**PREFERRED PROJECT REPORT
MP 08_0258**

61 MOBBS LANE, EPPING

APRIL 2010

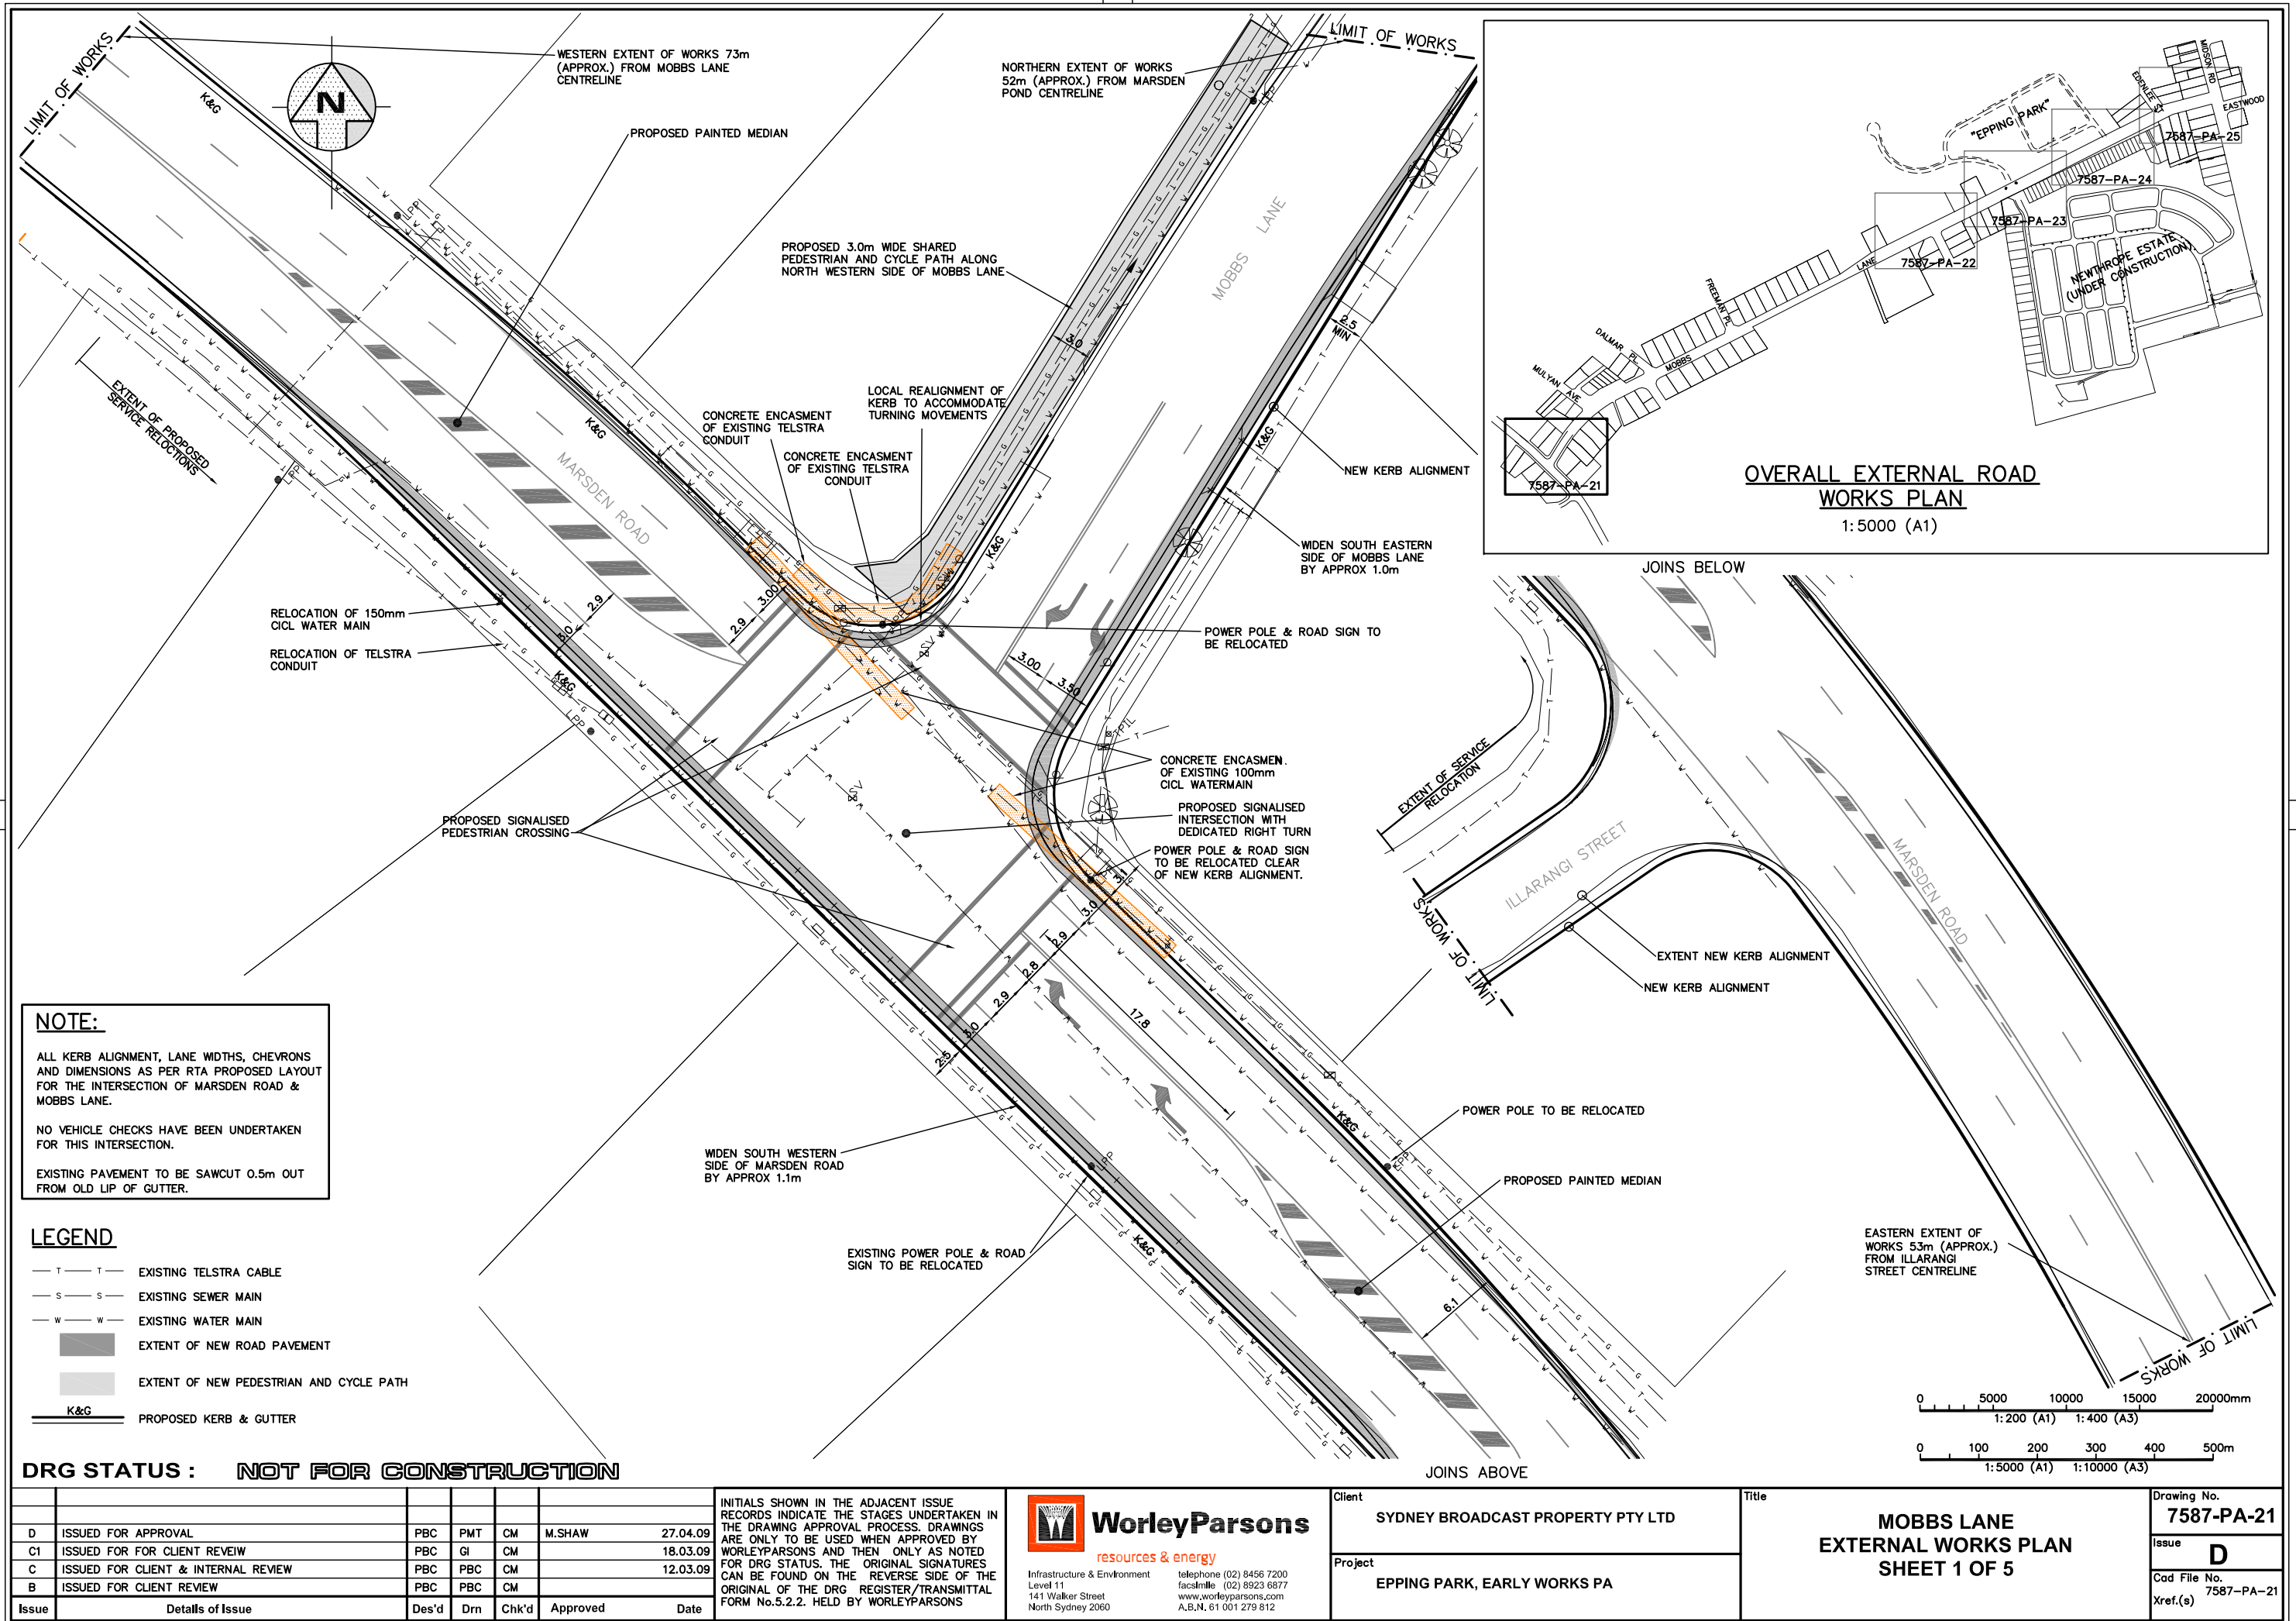
Mobbs Lane & Marsden Road intersection proposed traffic signals Drawing No 7587-PA-21

The matters raised under this heading of Council's submission can be imposed as a condition on the approval. This would apply to proposed Stage 3 of the development.

Drawing No.	7587-PA-22
Issue	D
Cad File No.	7587-PA-21
Xref(s)

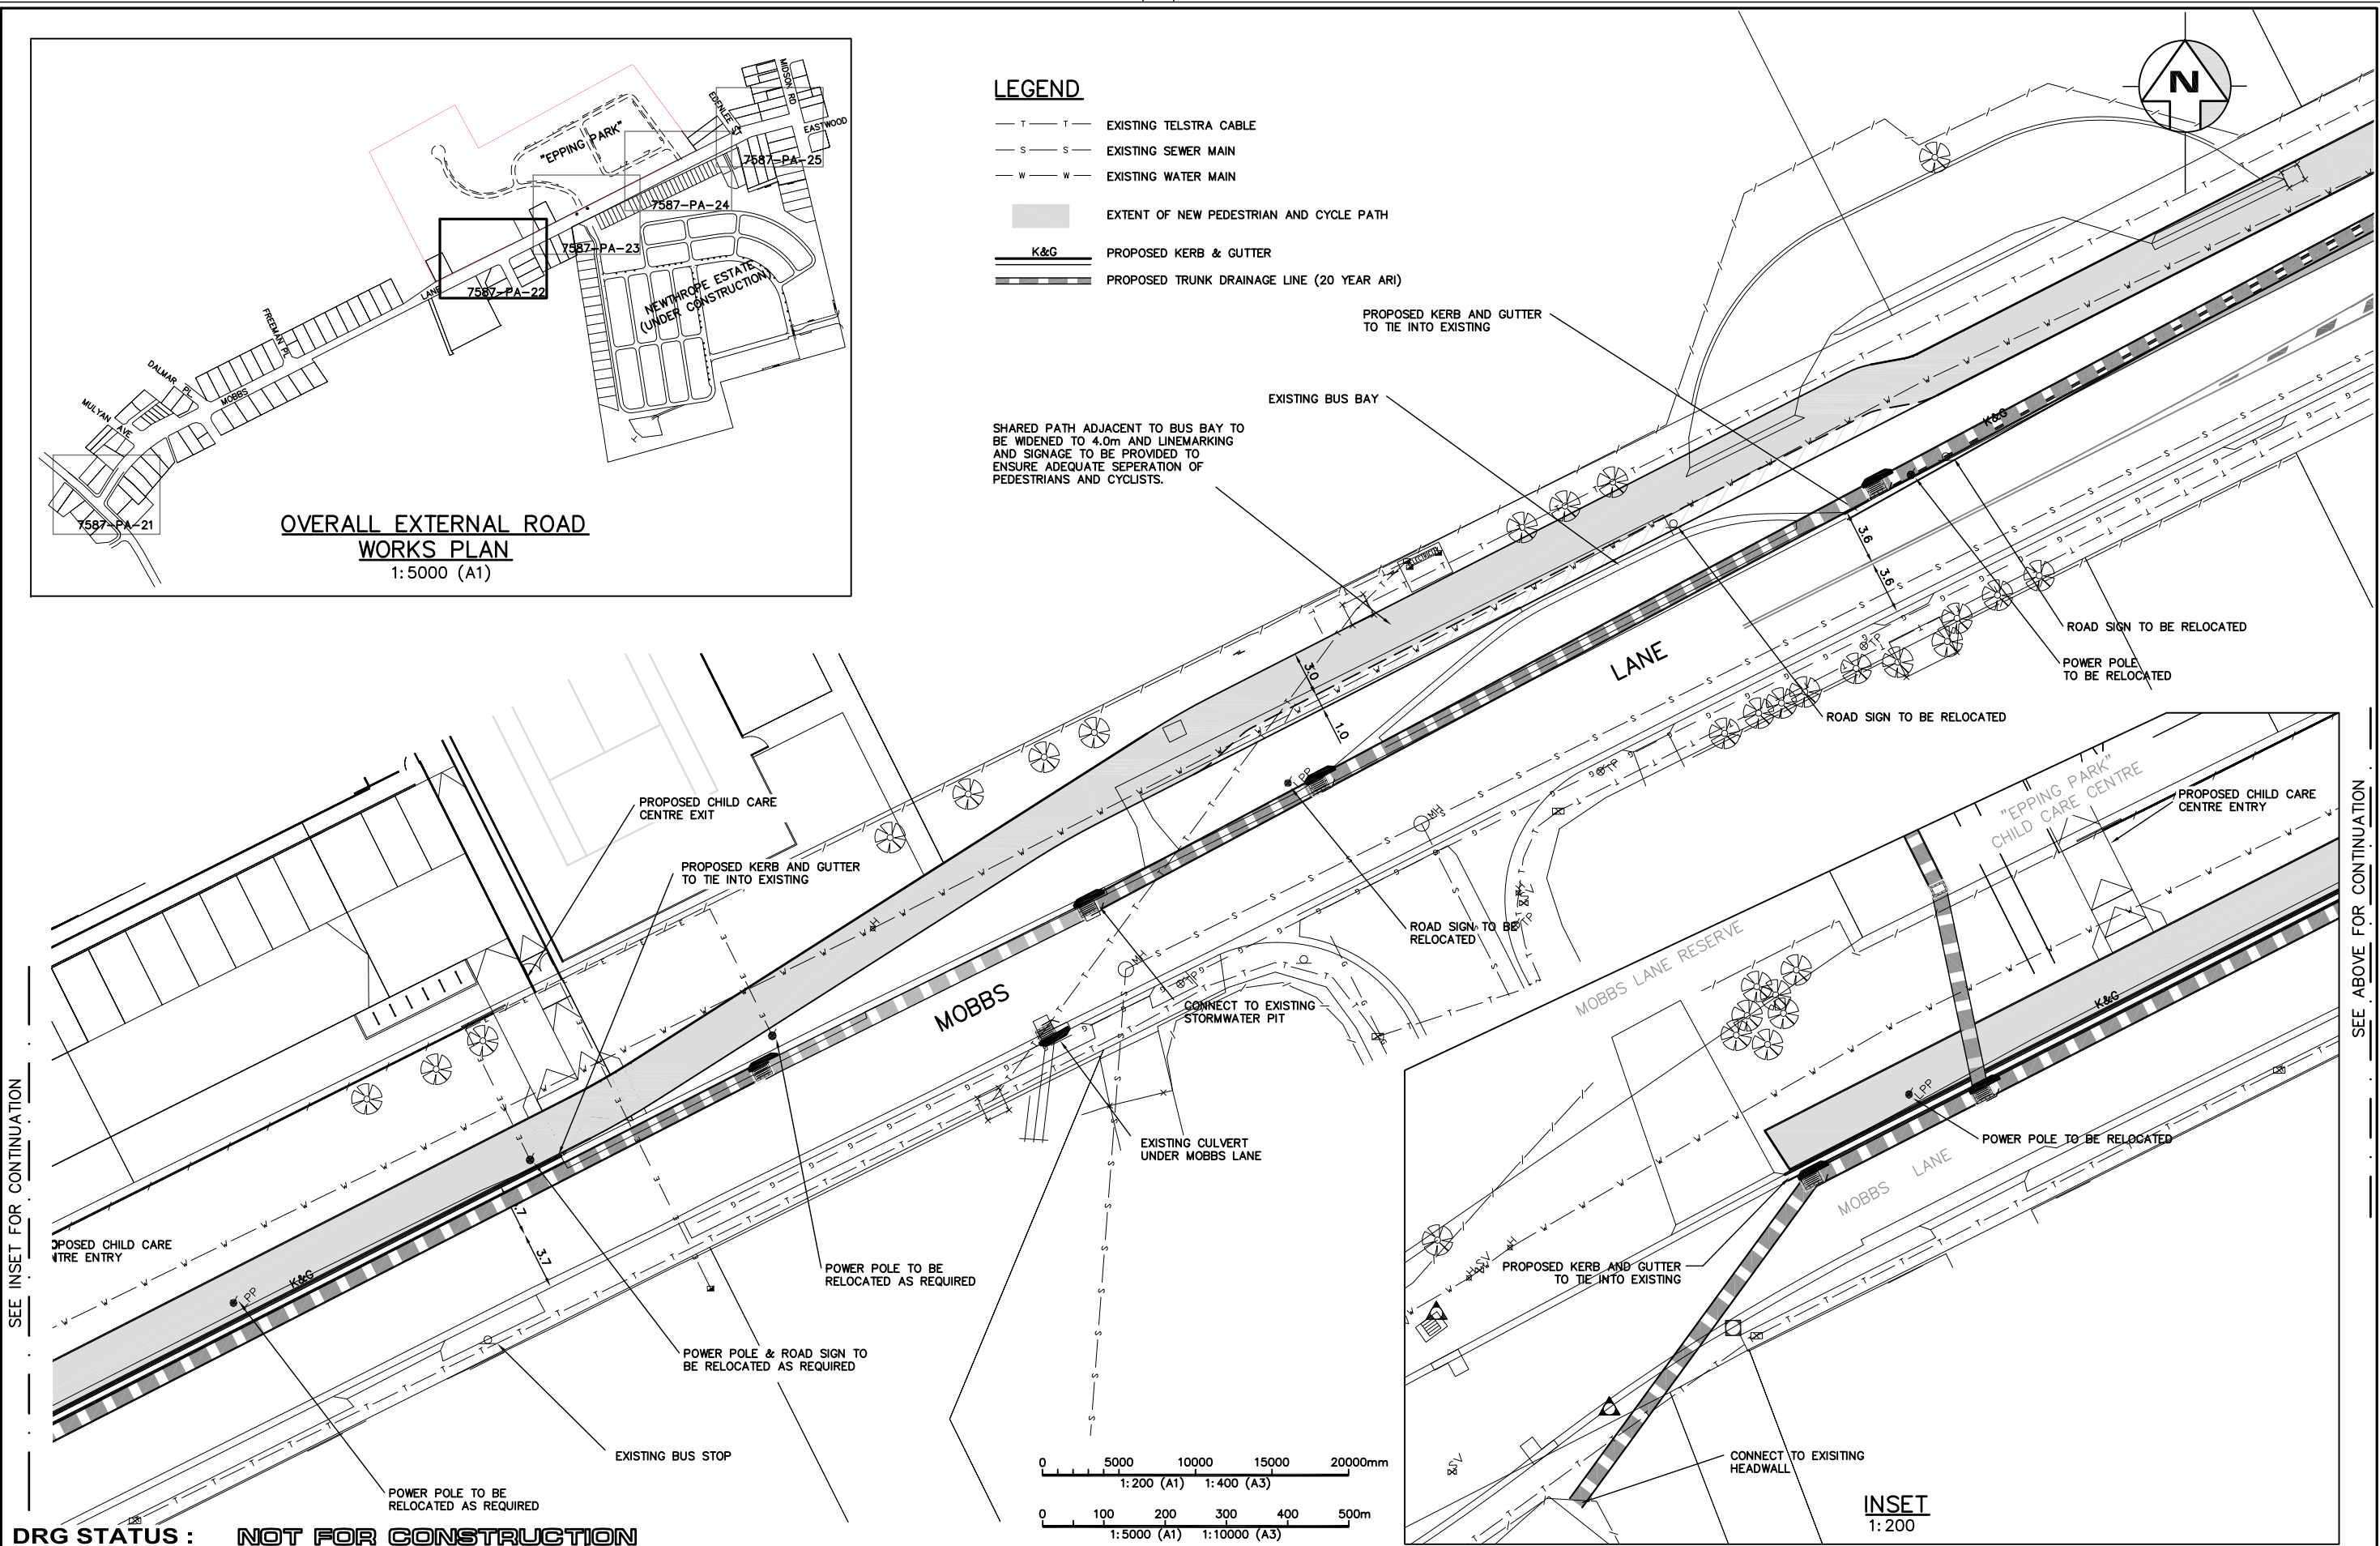
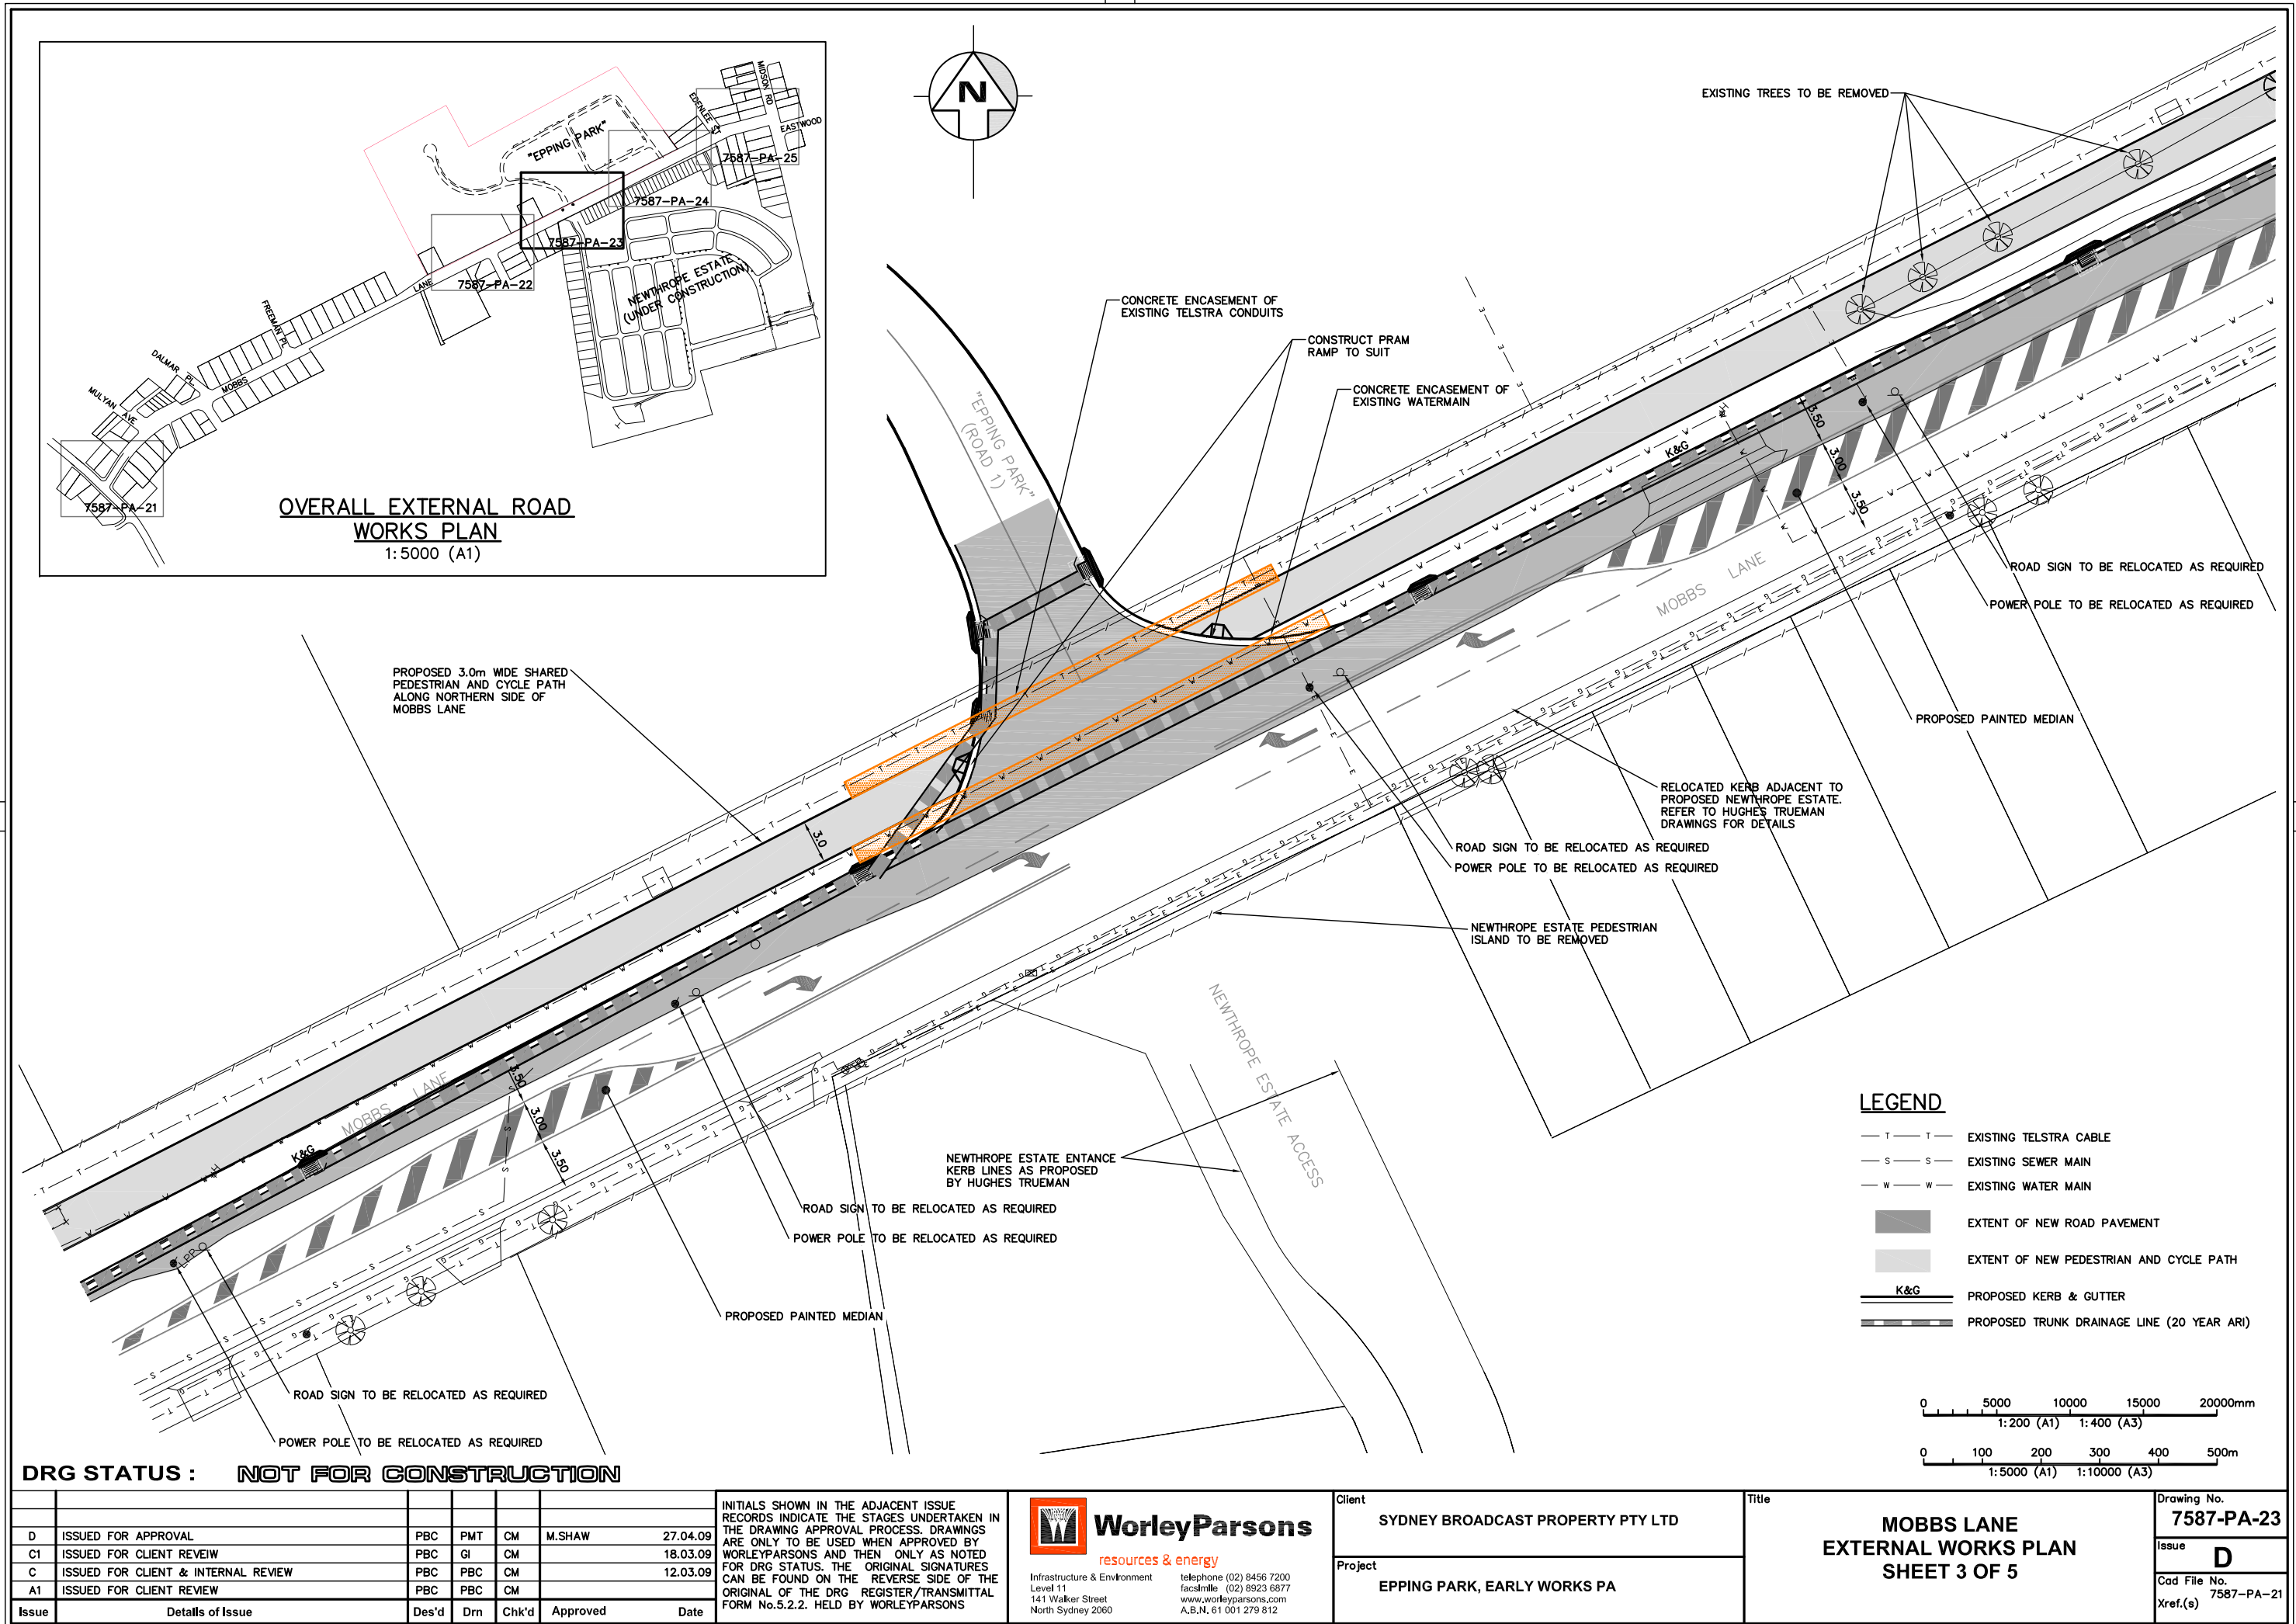
Drawing No. 7587-PA-22 to 25

The matters raised under this heading of Council's submission can be imposed as a condition on the approval. This would apply to proposed Stage 3 of the development.
